Application for removal or variation of a condition following grant of
planning permission. Town and Country Planning Act 1990.
Planning (Listed Buildings and Conservation Areas) Act 1990

Number	
Suffix	
Property name	Copsefield
Address line 1	Eastergate Lane
Address line 2	
Address line 3	
Town/city	Eastergate
Postcode	PO20 3SJ
Description of site location must be completed if postcode is not known:	
Easting (x)	495374
Northing (y)	106064
Description

1 No. dwelling with access from The Drive and conversion of 2 No. dwellings into 1 No. dwelling, including side and rear extensions and detached garage.	
Reference number	
EG/50/16/PL	
Date of decision (date must be pre-application submission)	22/11/2016
Please state the condition number(s) to which this application relates	
Condition number(s)	
2.

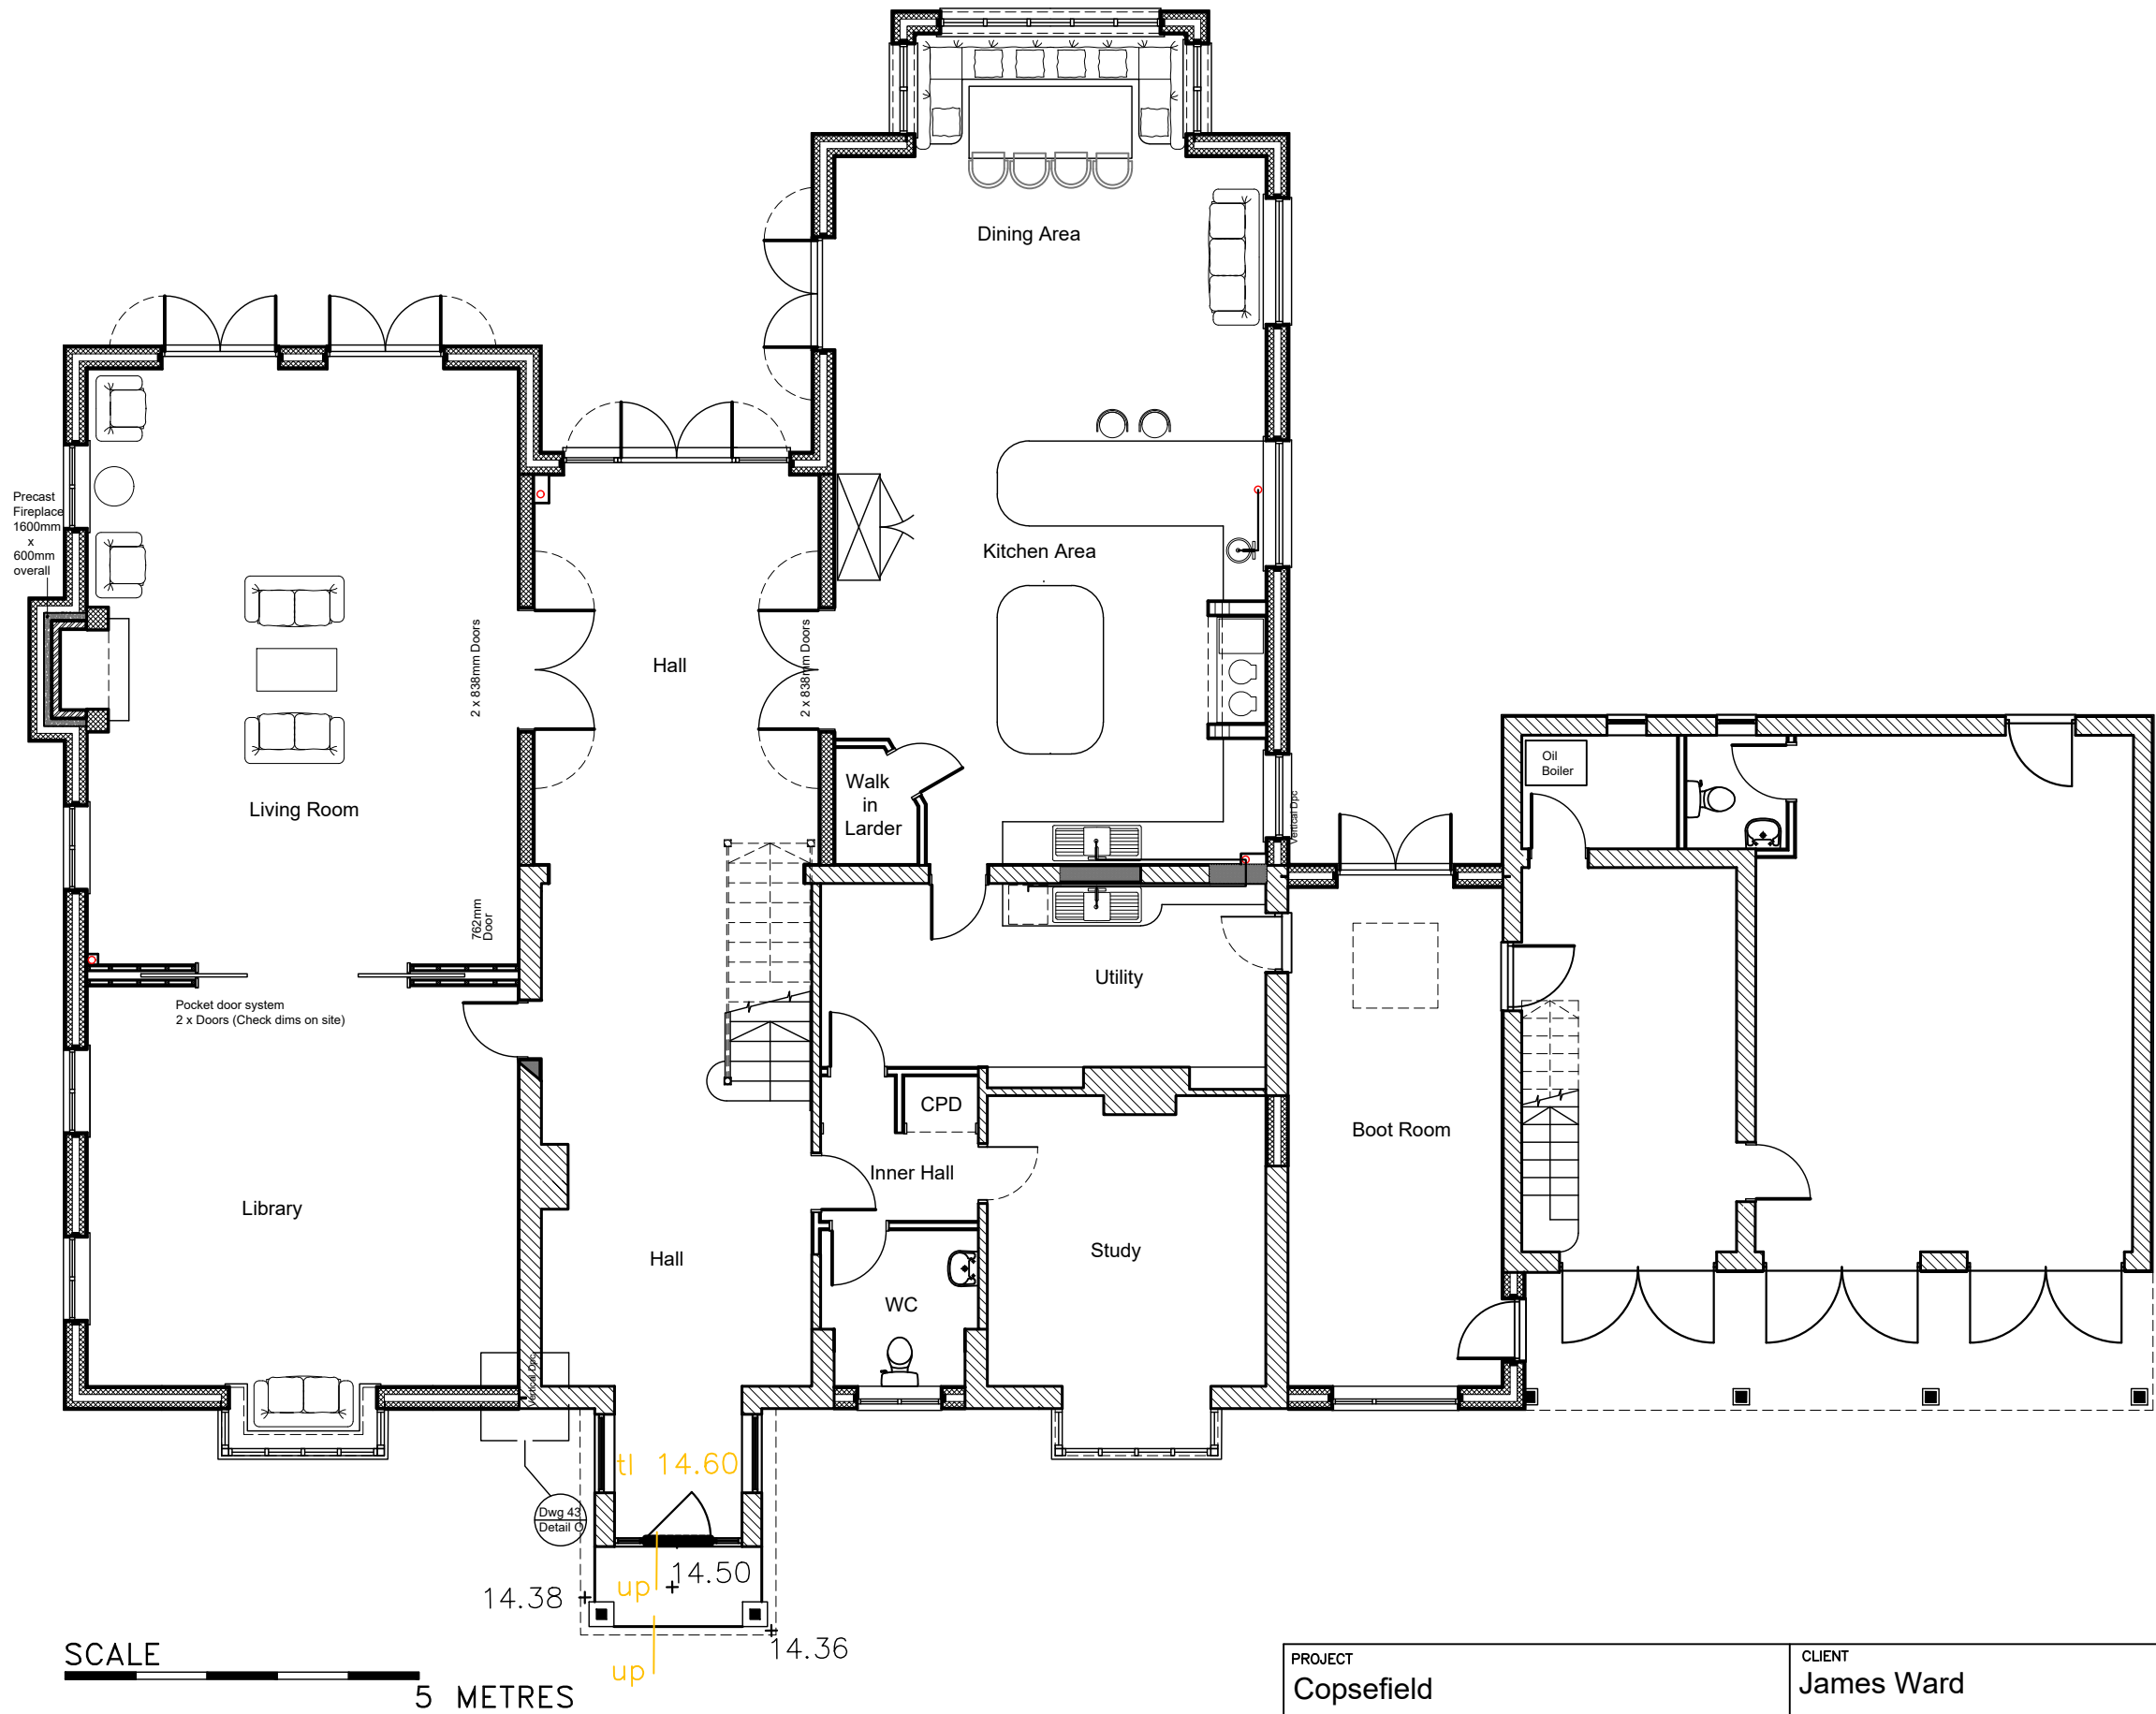
The principle change being the retention of the main masonry walls of the original garage instead of demolishing it and building the new detached garage. Primarily this was due to economic and sustainability factors. Also, it is proposed to link the garage building to the main house with a utility and boot room. We trust this is an acceptable and practical proposal.
